Ribble Valley Borough Council
By email

Your ref: 3/2025/0318
Our ref: DC/25/1156
Date: 27-MAY-25

Location: The Old Garage Site Newton Road Dunsop Bridge BB7 3BB

Proposal: Approval of details reserved by conditions 4 (location of existing water mains and sewers), 5 (drainage scheme),10 (surface water drainage car park))

Client		The Duchy of Lancaster	
Project		Old Garage Site Dunsop Bridge	
Drawing title		Drainage Proposals	
Drawn	PB	Chkd	Date
Sheet Size	A1	Drawing No.	23120-DR-C-0120
Scale	var	Revision	P9

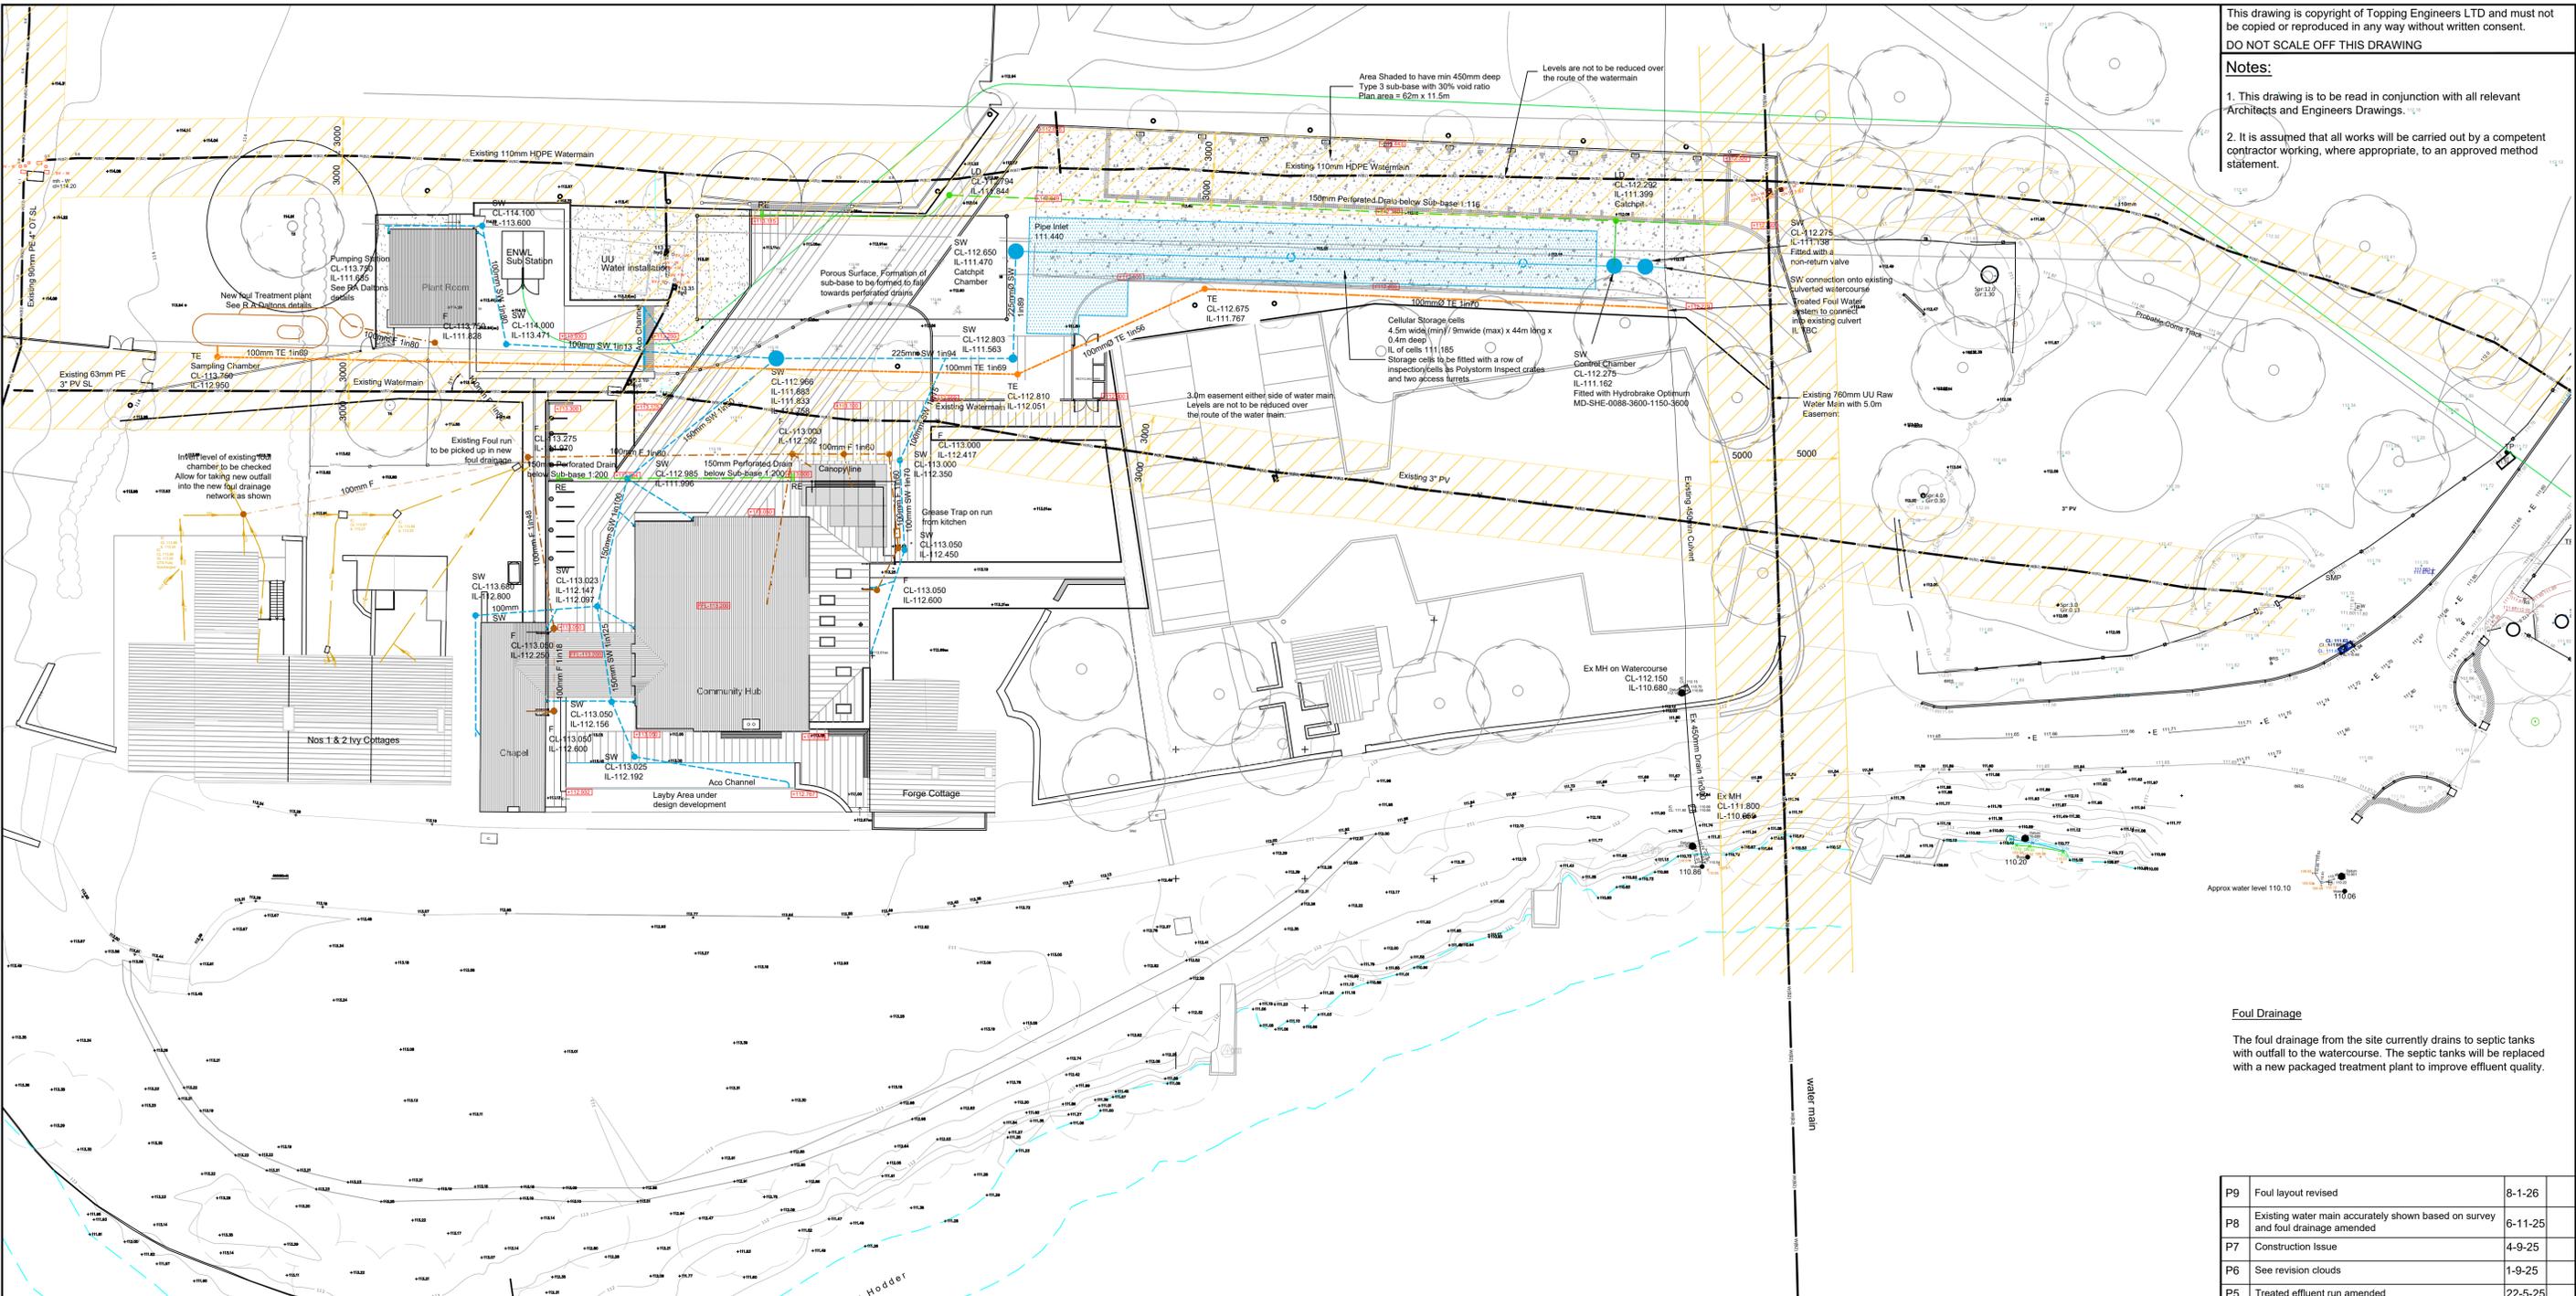
Further to our review of the submitted documents, Drainage Proposals, Rev P4 - Dated Oct 24, United Utilities recommends that condition 4 is not discharged. This is because we require evidence of the **PROVEN** location of the water main to ensure any proposed features have sufficient clearance. Please can you also provide evidence of any crossings of the existing existing water mains and sewers. The aqueduct also has a formal legal easement so there shall be no works within this easement before consulting with United Utilities as per standard conditions document. There is no indication they have located the water in agreement with United Utilities. The pre-commencement survey does not extend over the route of the main. We want the applicant to outline how they are to protect assets during construction, which has not been provided. The requirements of the condition must be revisited and addressed in revised information submitted to us for review.

We must note that the proposed location of the cellular storage cells would not be permitted as they would fall within the 30" main easement.

Drawn	PB	Chkd		Date	Oct 2024	Scale	var
Sheet Size	A1	Drawing No.	23120-DR-C-0120	Revision			P4

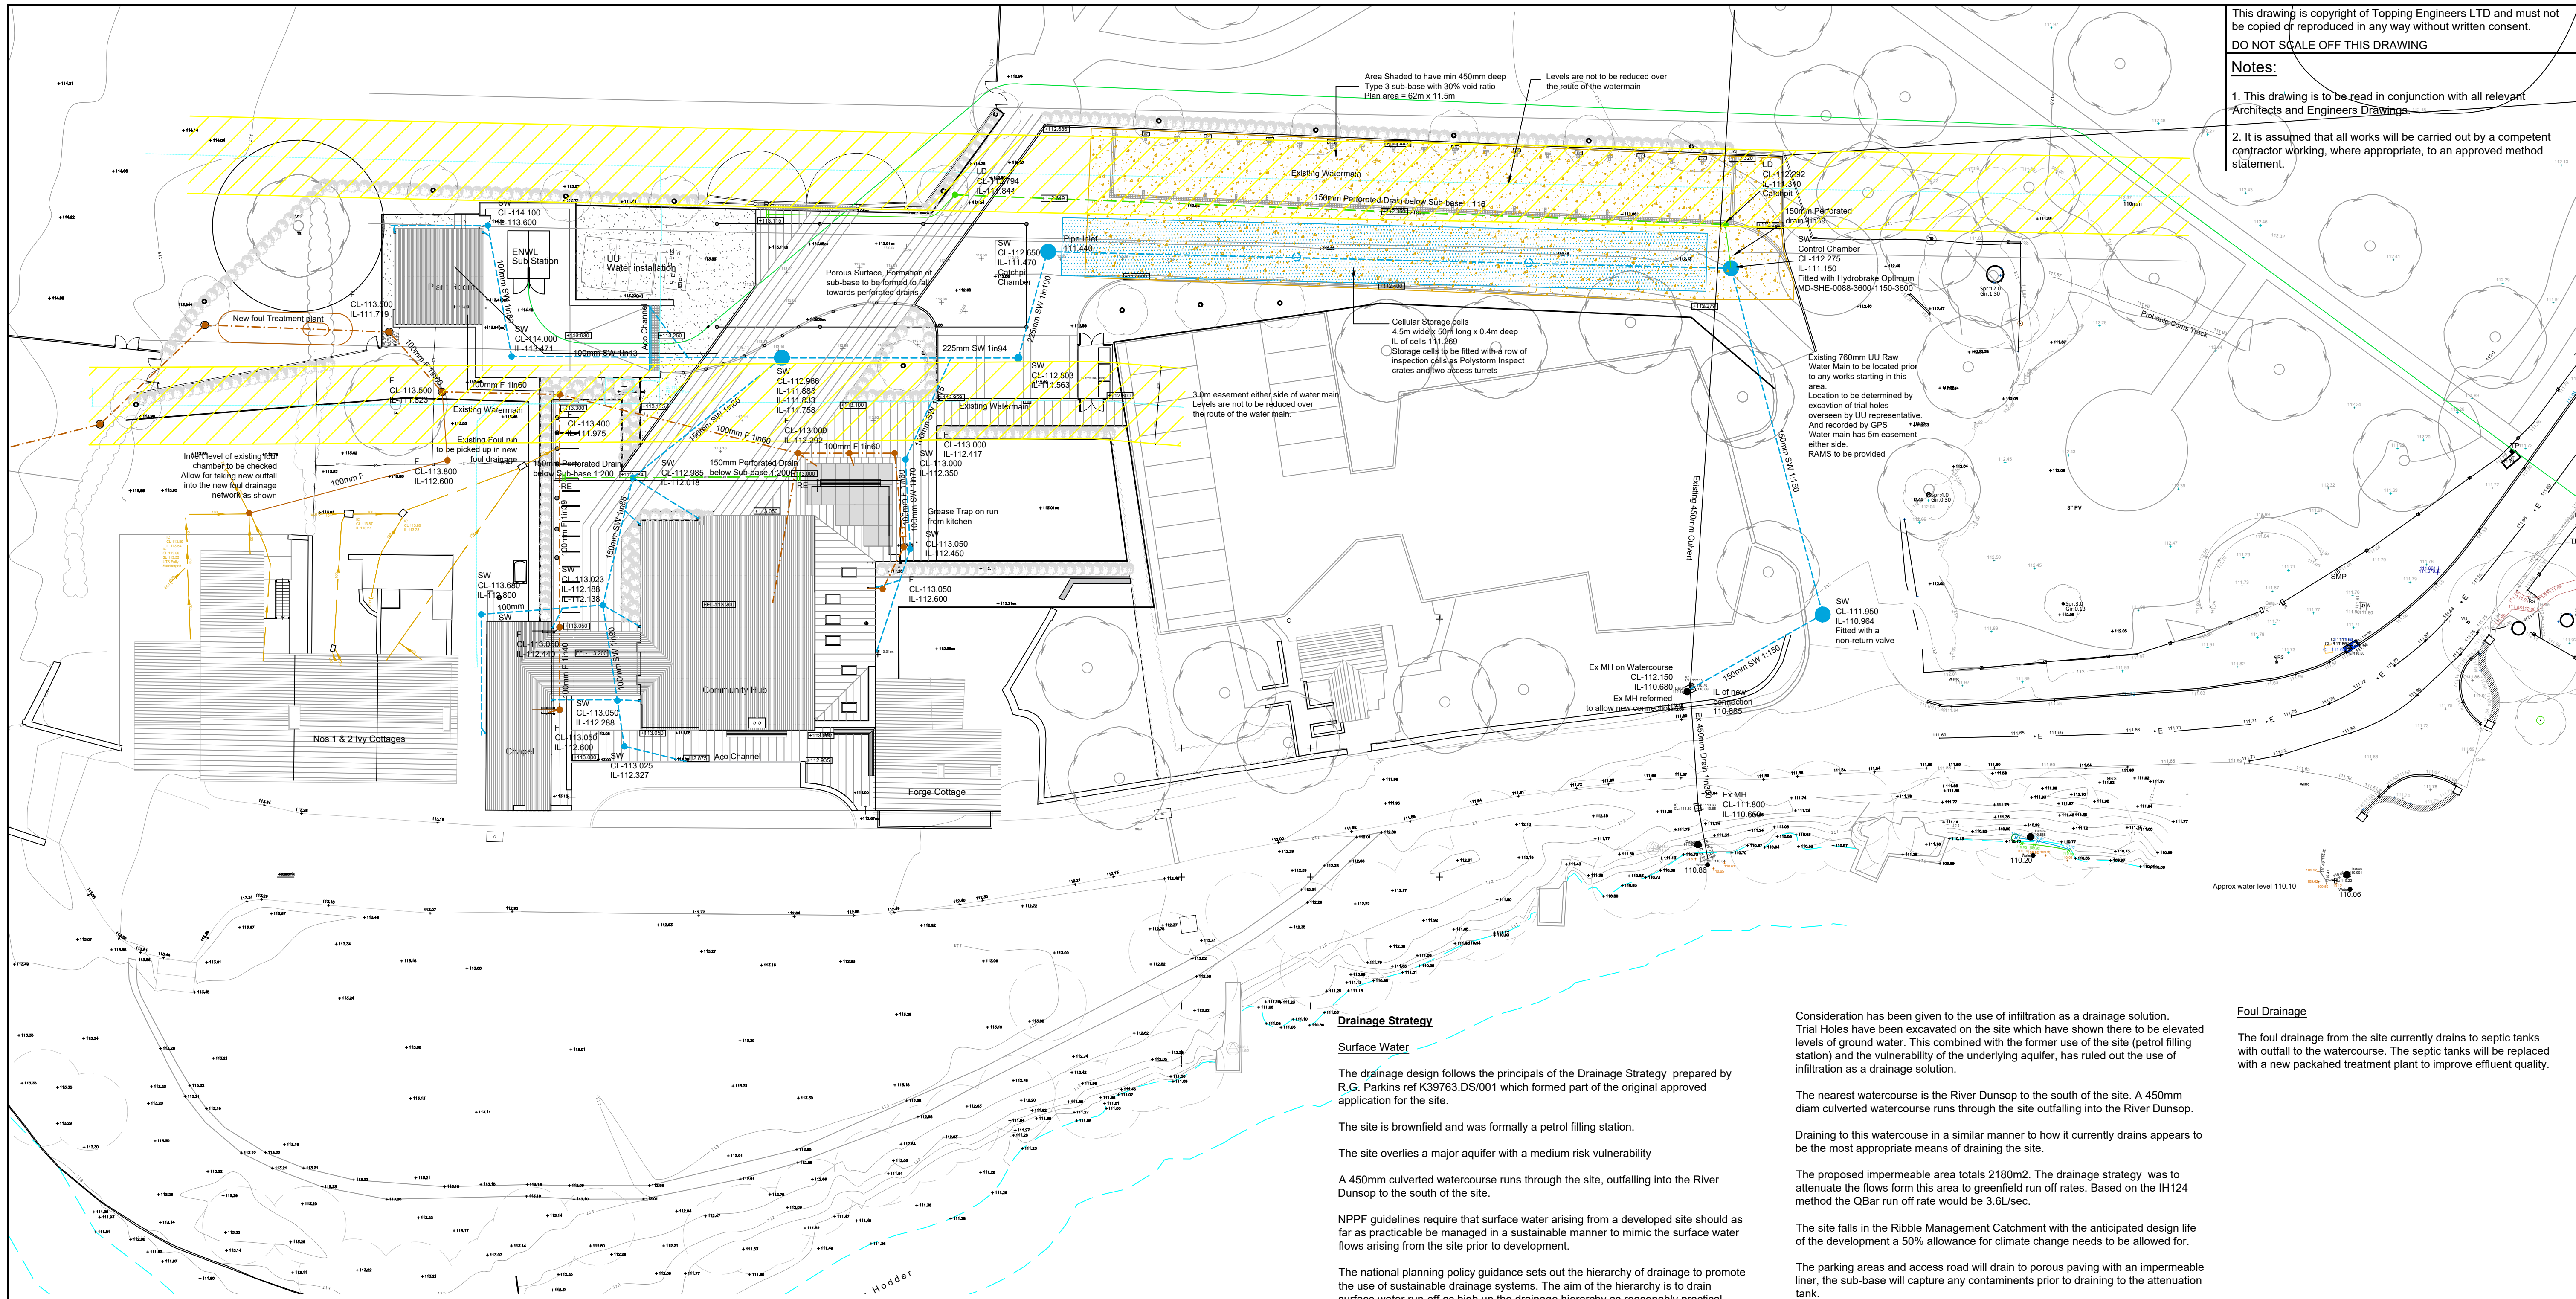
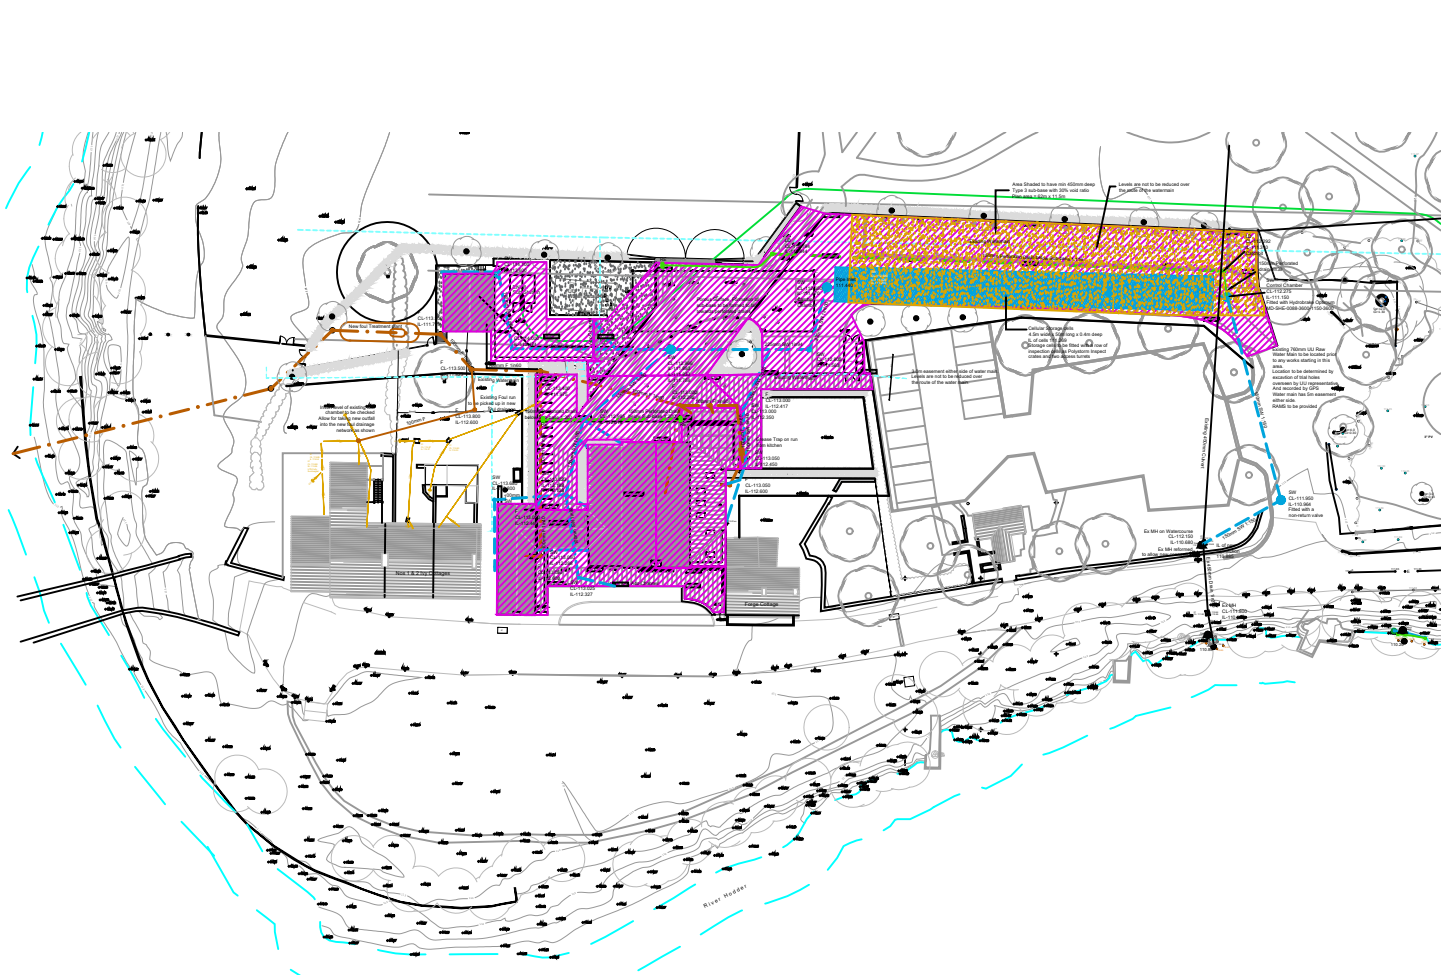
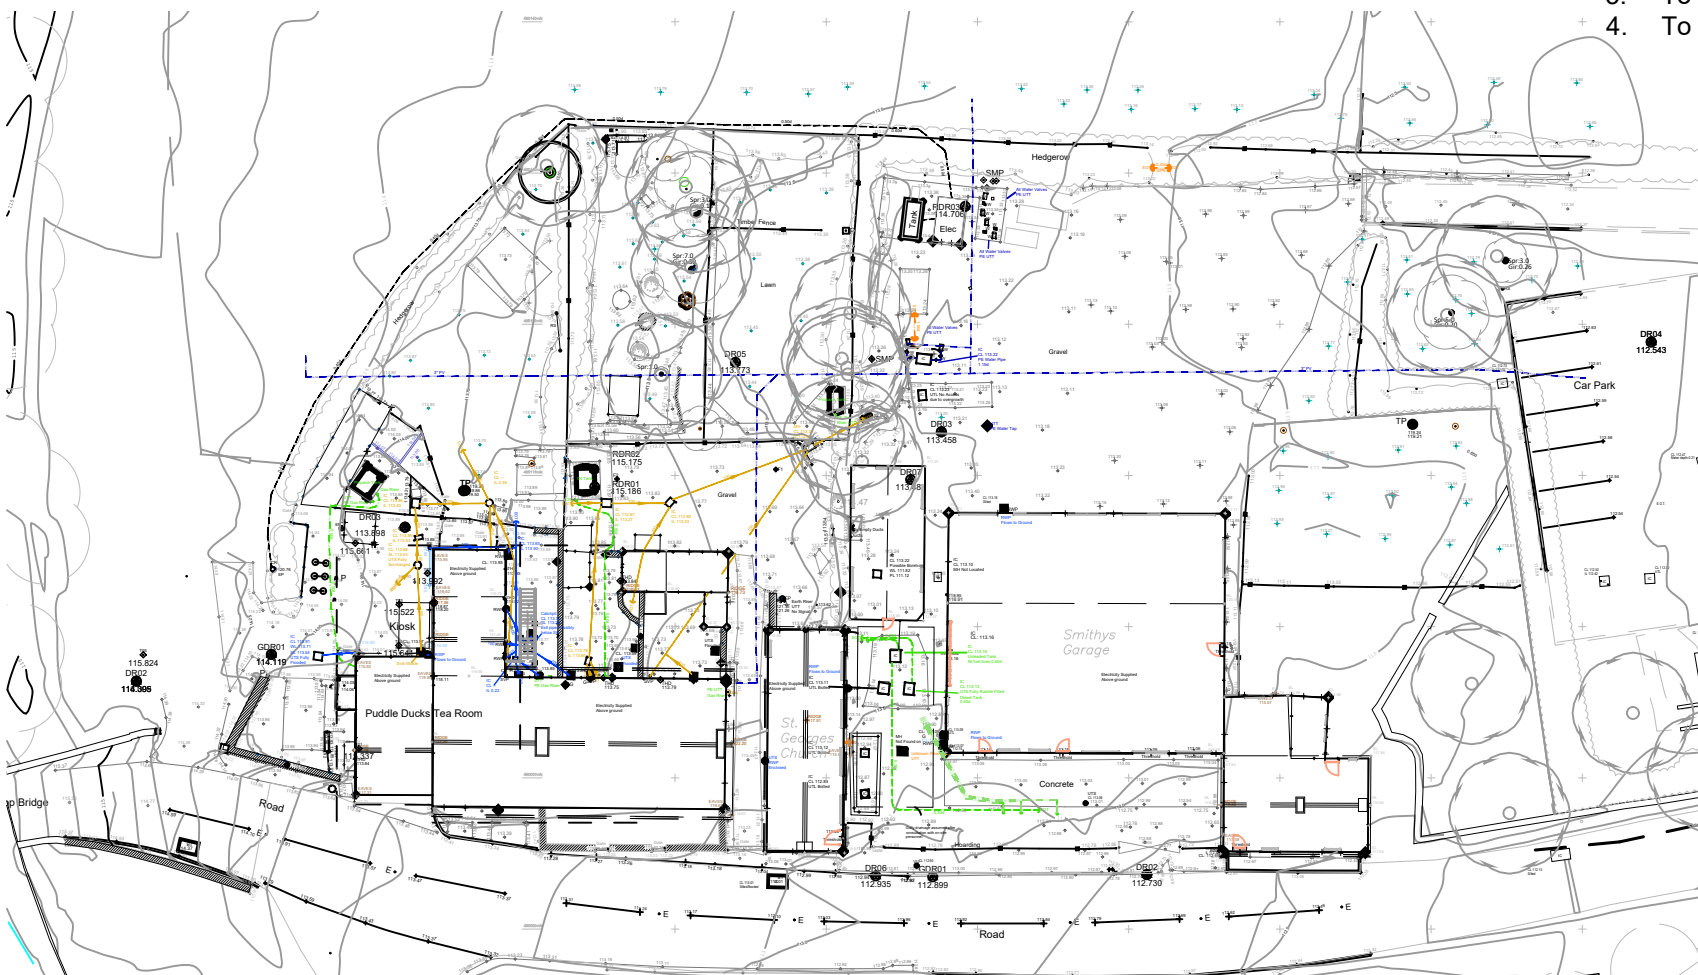
Further to our review of the submitted documents, Drawing 23120-DR-C-0120, Rev P4 - Dated 15.04.2025, United Utilities recommends that condition 5 is not discharged. This is because the drawing indicates that the proposals drain to what is a treated raw water pipeline. The applicant must confirm the discharge point and understand any surface water culvert they are proposing to connect to is a suitable option for surface water discharge.
